PLANNING AMENDMENT

Application No. **H08/0076/95**

DEMOLISH REMAINS OF FIRE DAMAGED GARAGE & REBUILD IN MATCHING STYLE & MATERIALS.

AMEND ENTRY DOOR & OUT 'TURN' WALL FIVE' & SUBSTITUTE BRICK ALTERNATIVE & RE-ARRANGE OIL STORE / STORE LAYOUT.

AMENDED PLAN
 Ref. A/
 HOUSING & PLANNING
 30 OCT 1995
 Ref. 0076/45

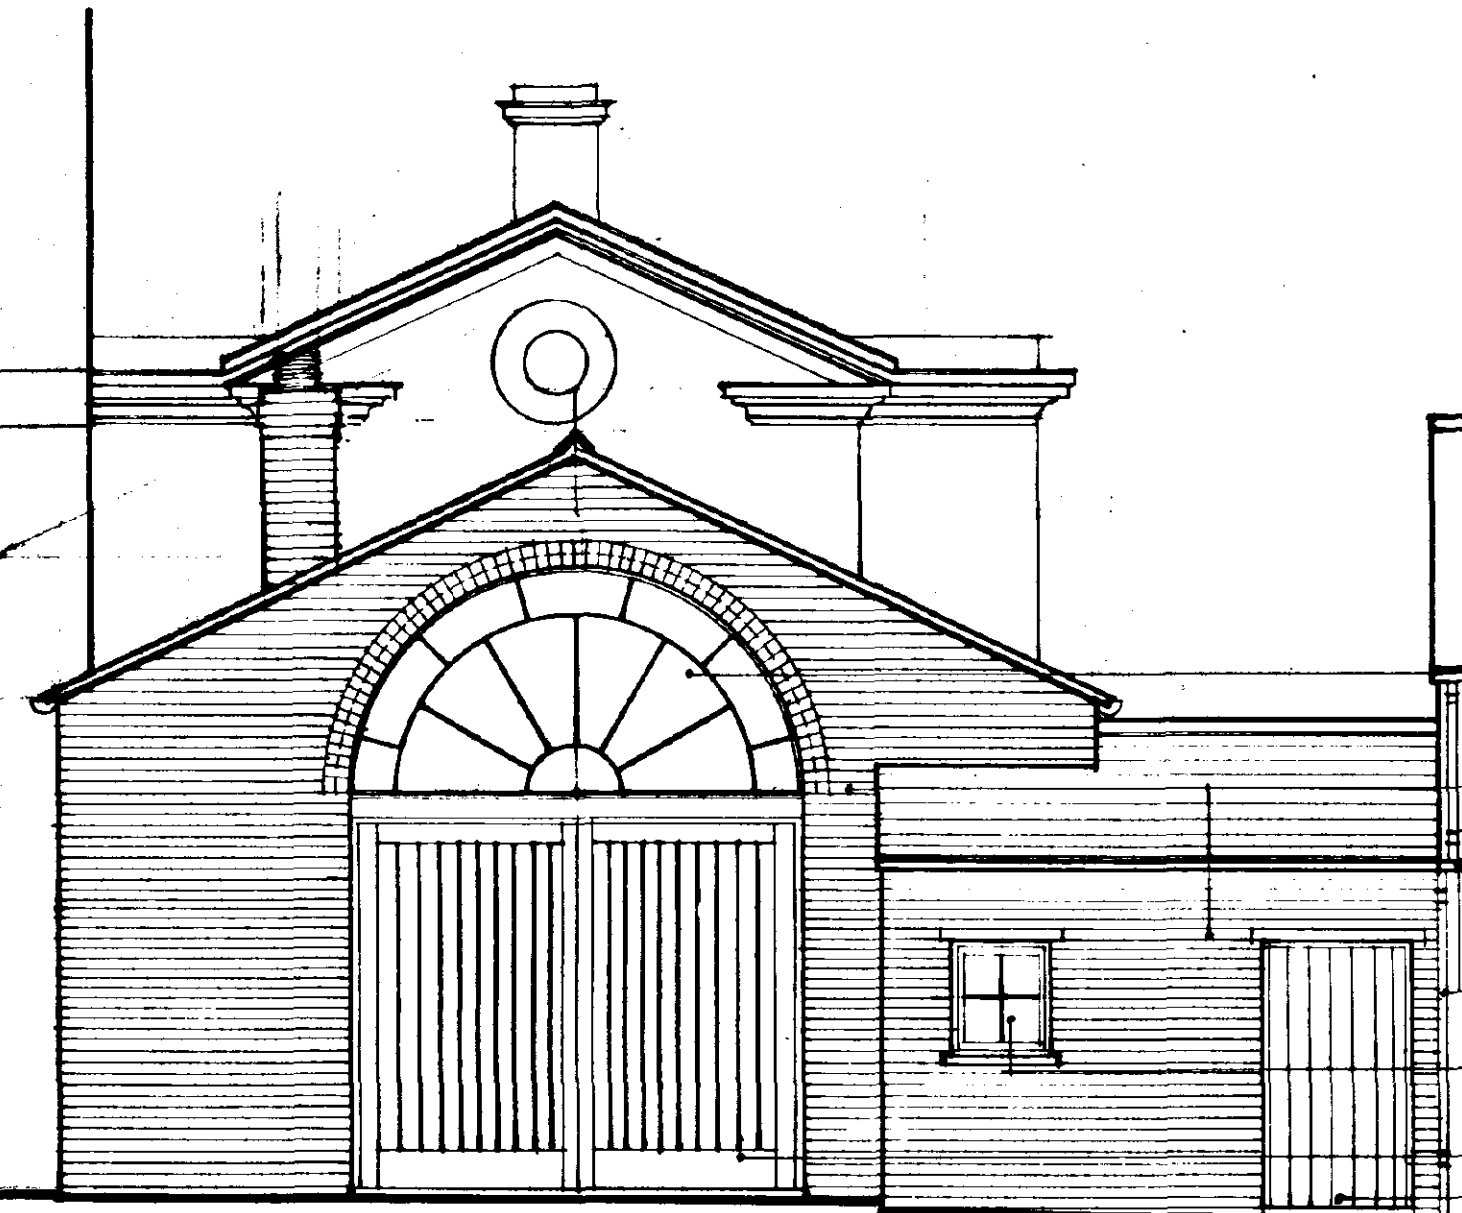
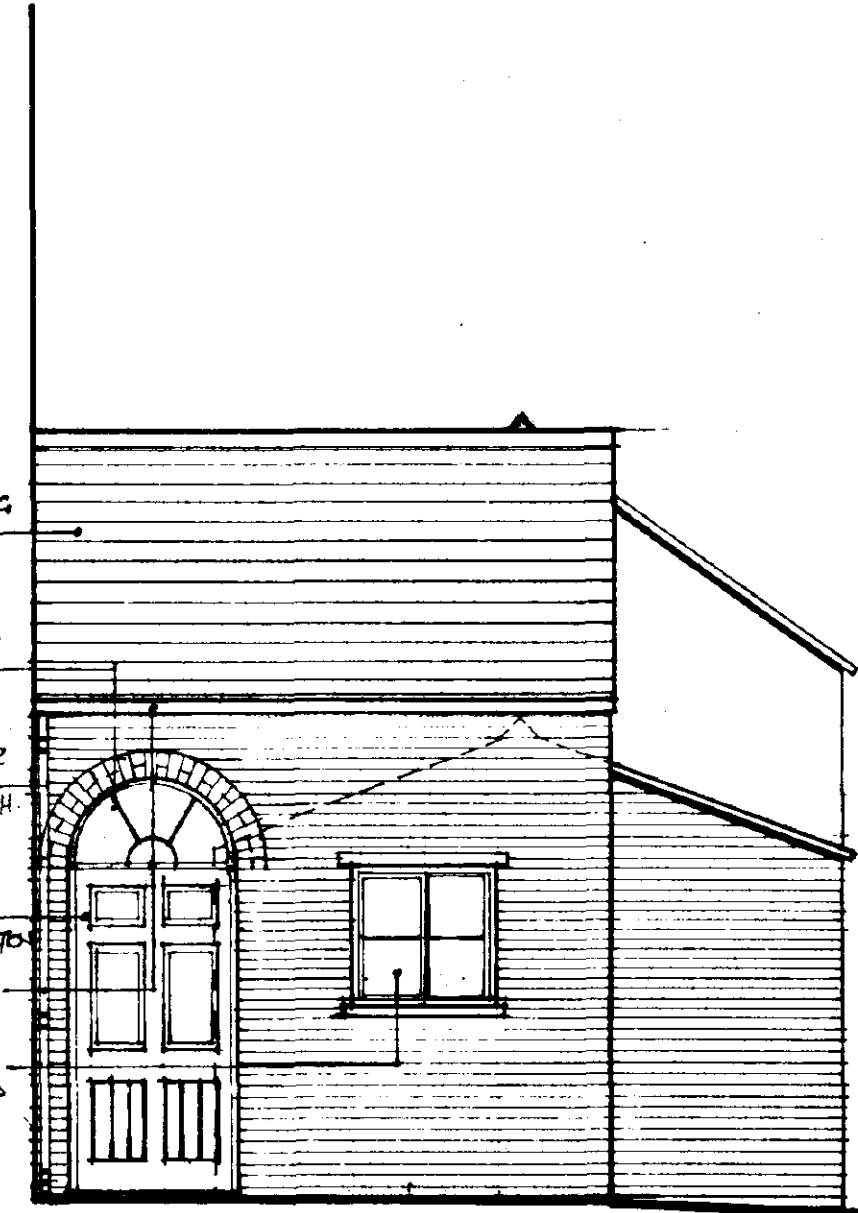
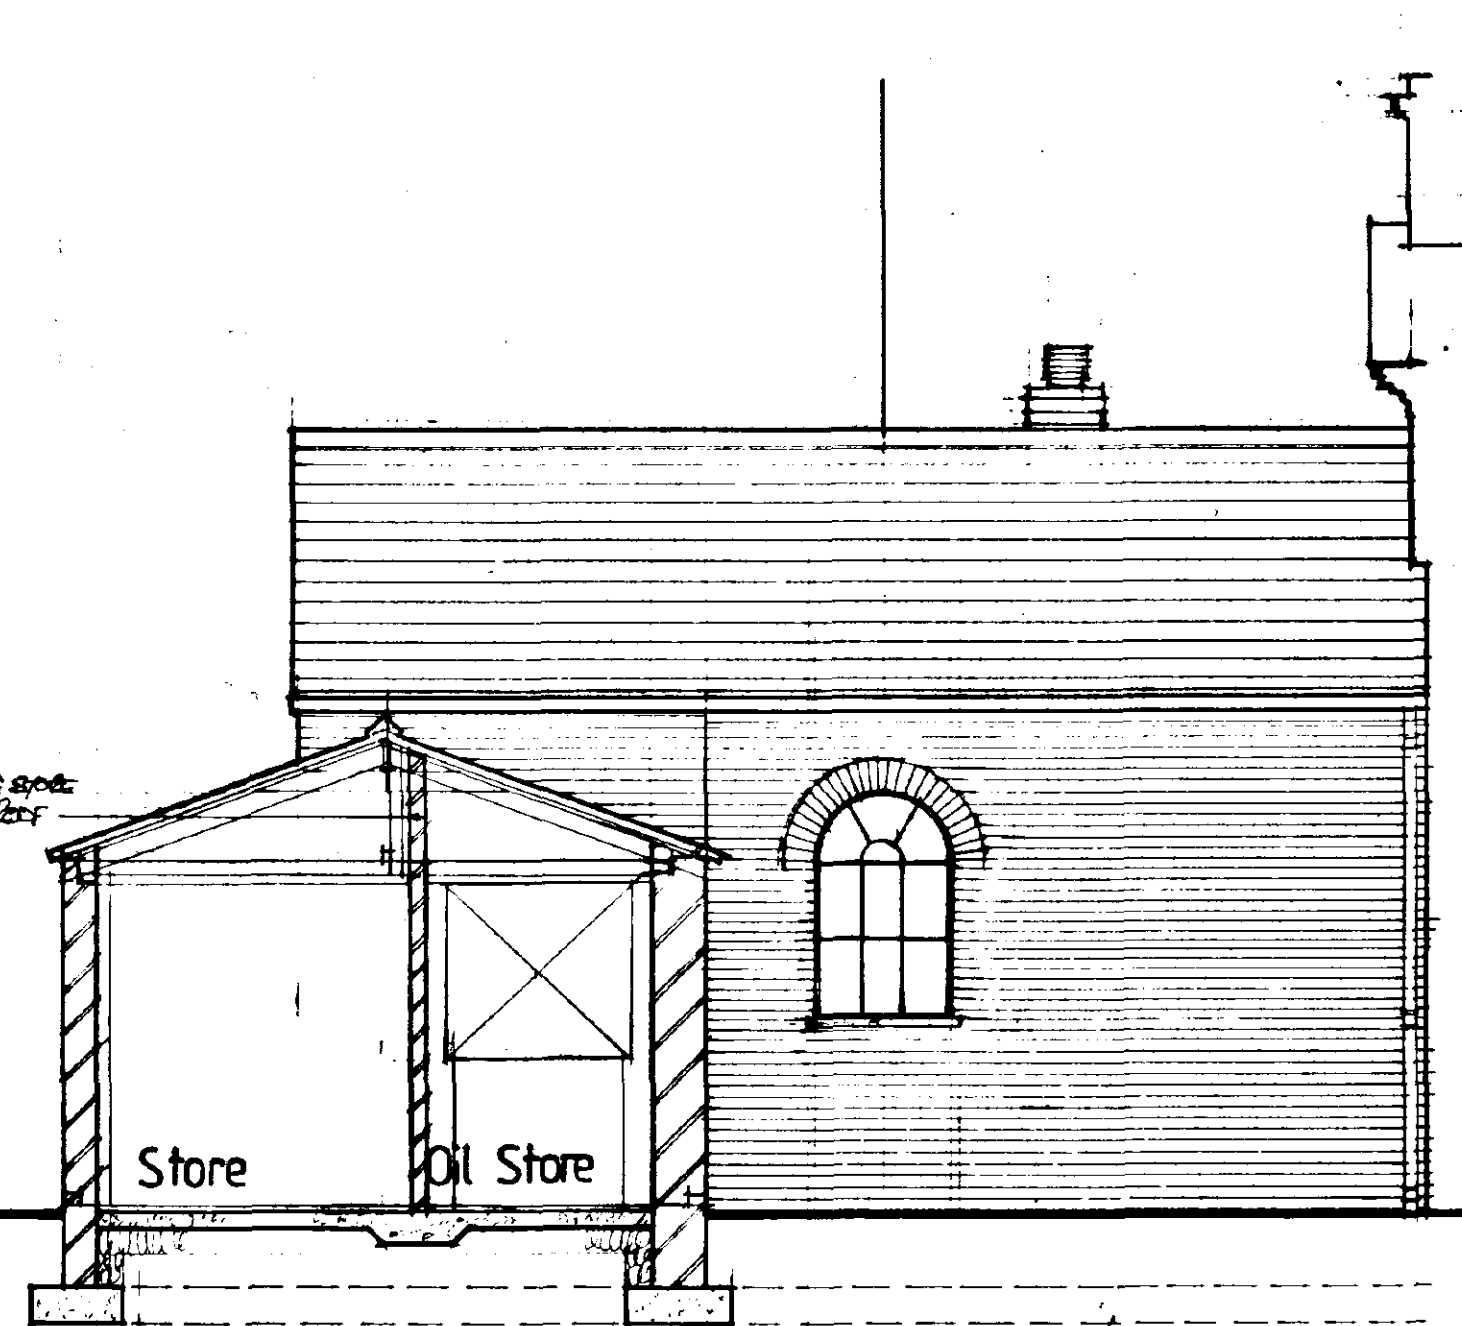
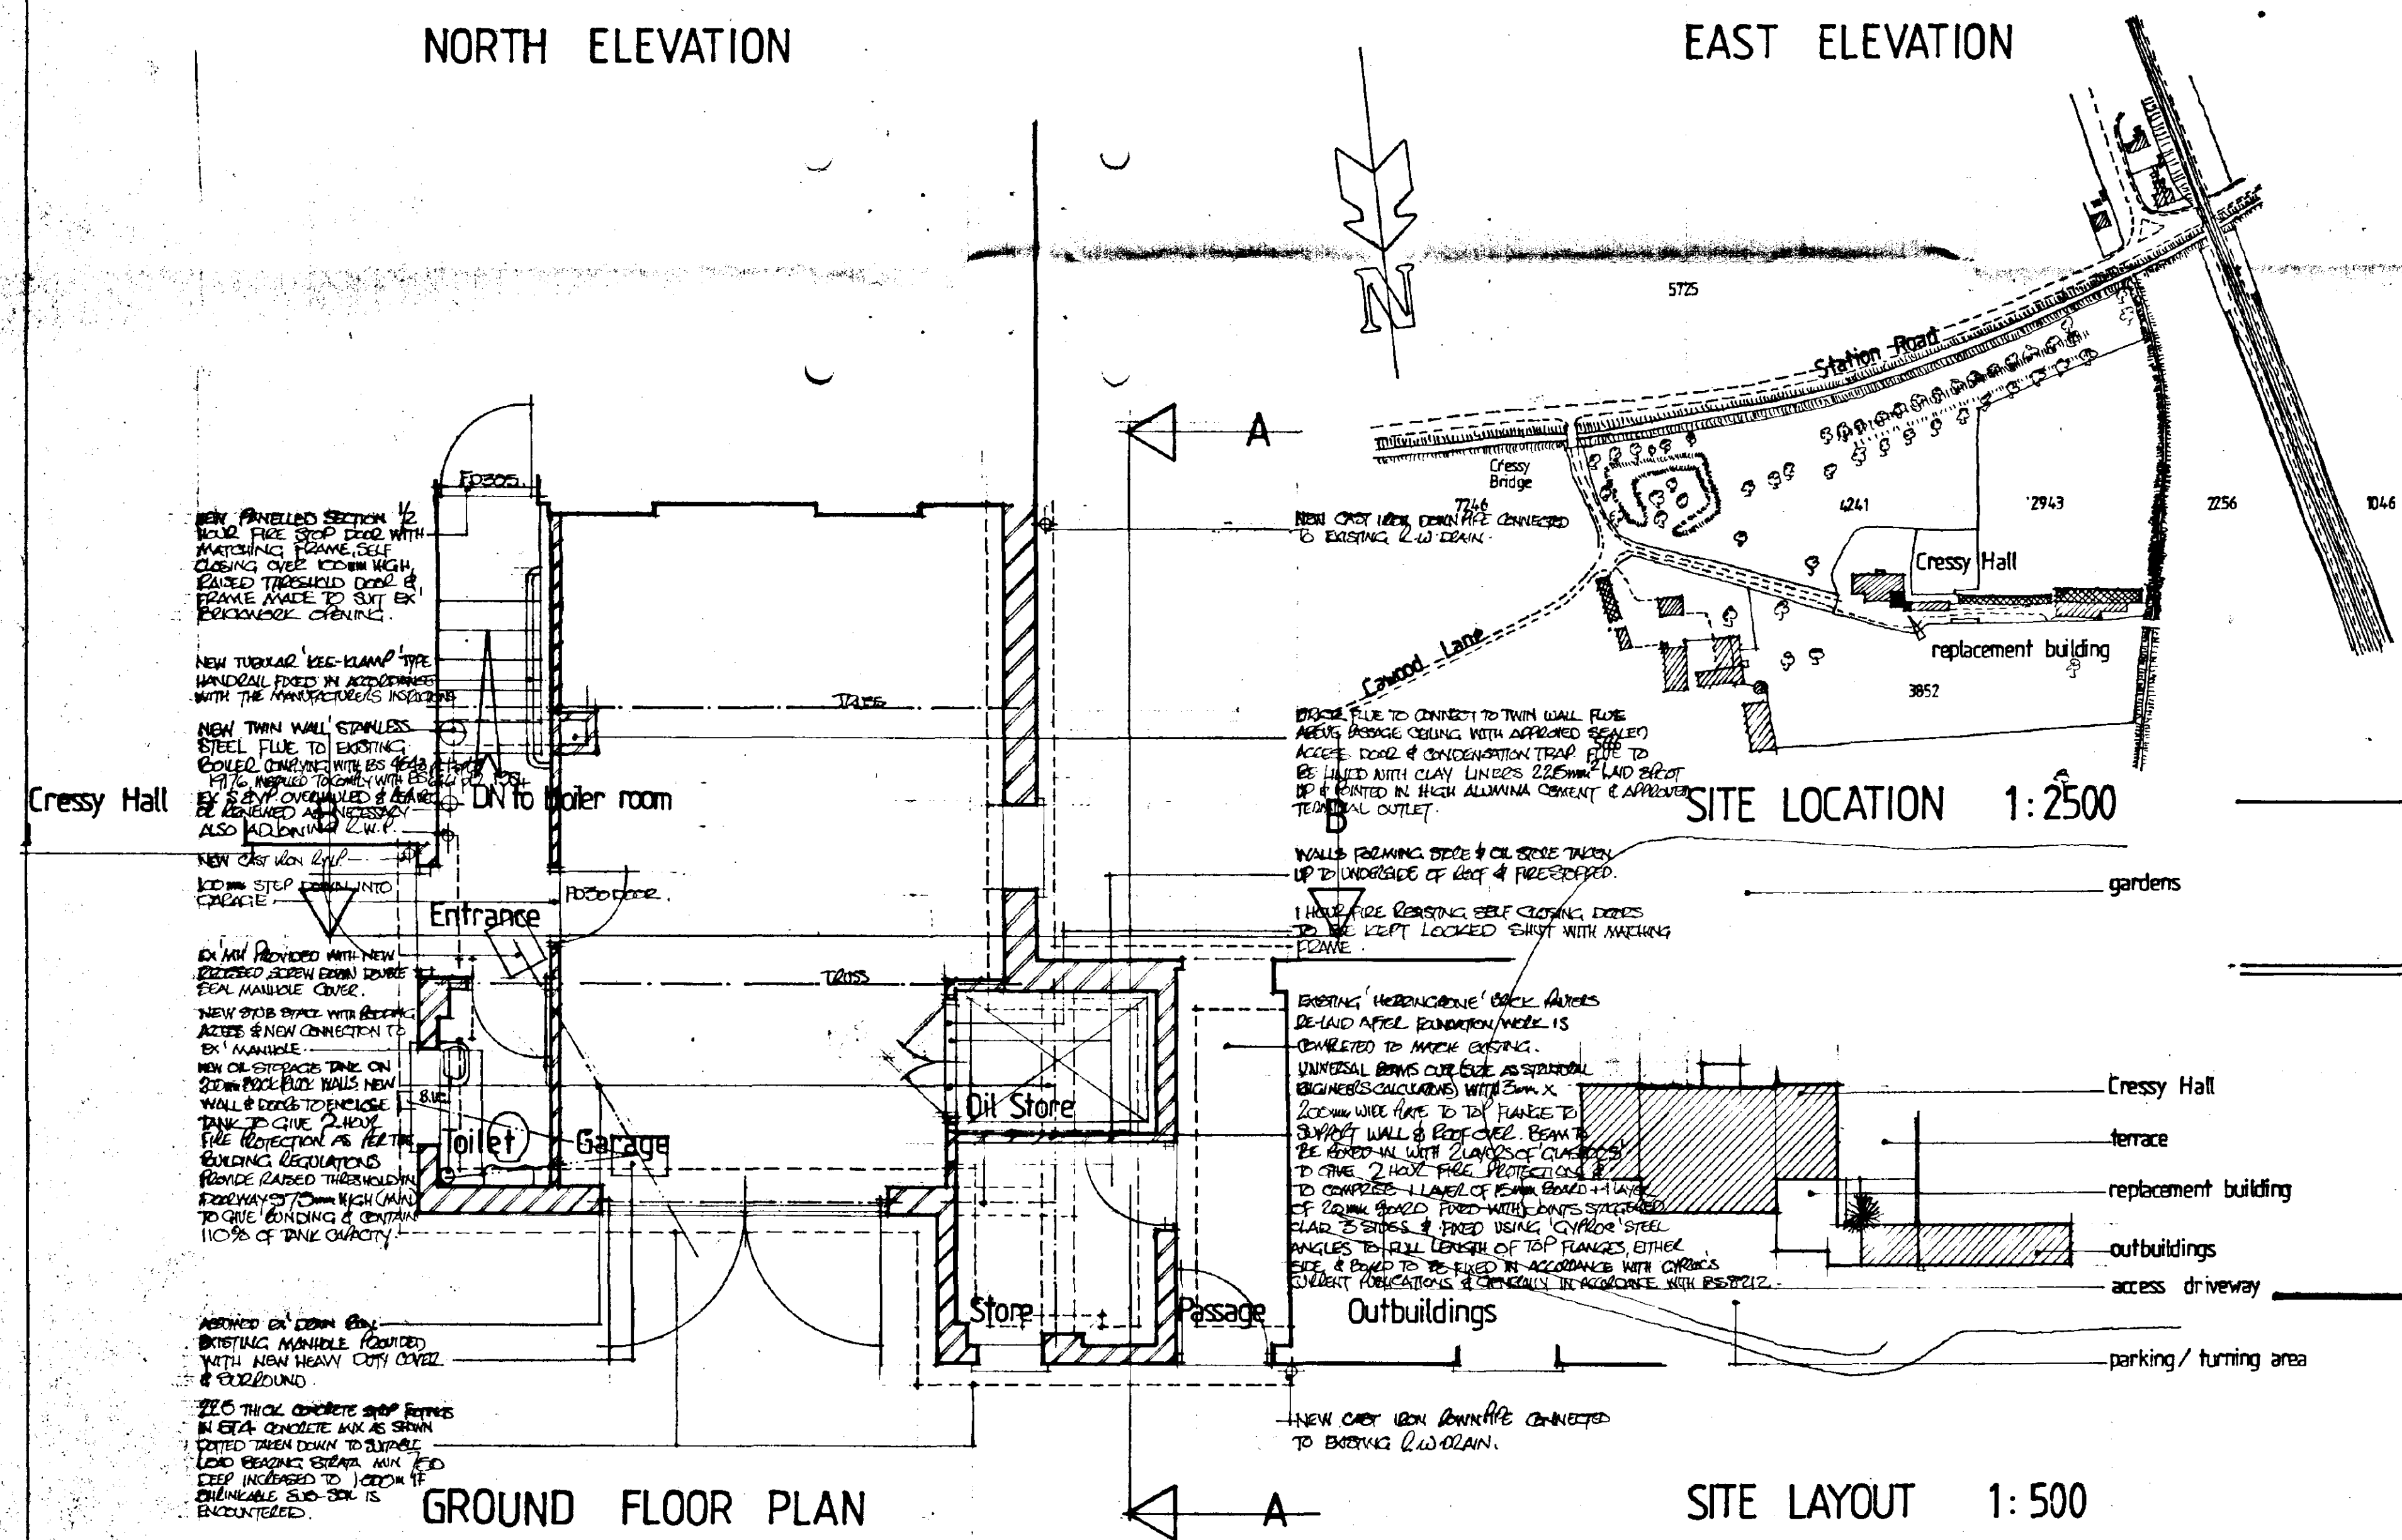
Amendment Submitted: Amendments to entry door, "Twin Wall" flue and oil sto
Drawing No. 94:40:2A.

Amend entry door in East Elevation.
Insert window^{+door} in West Elevation.
Substitute Pine with brick chimney.
Rearrange internal layout.
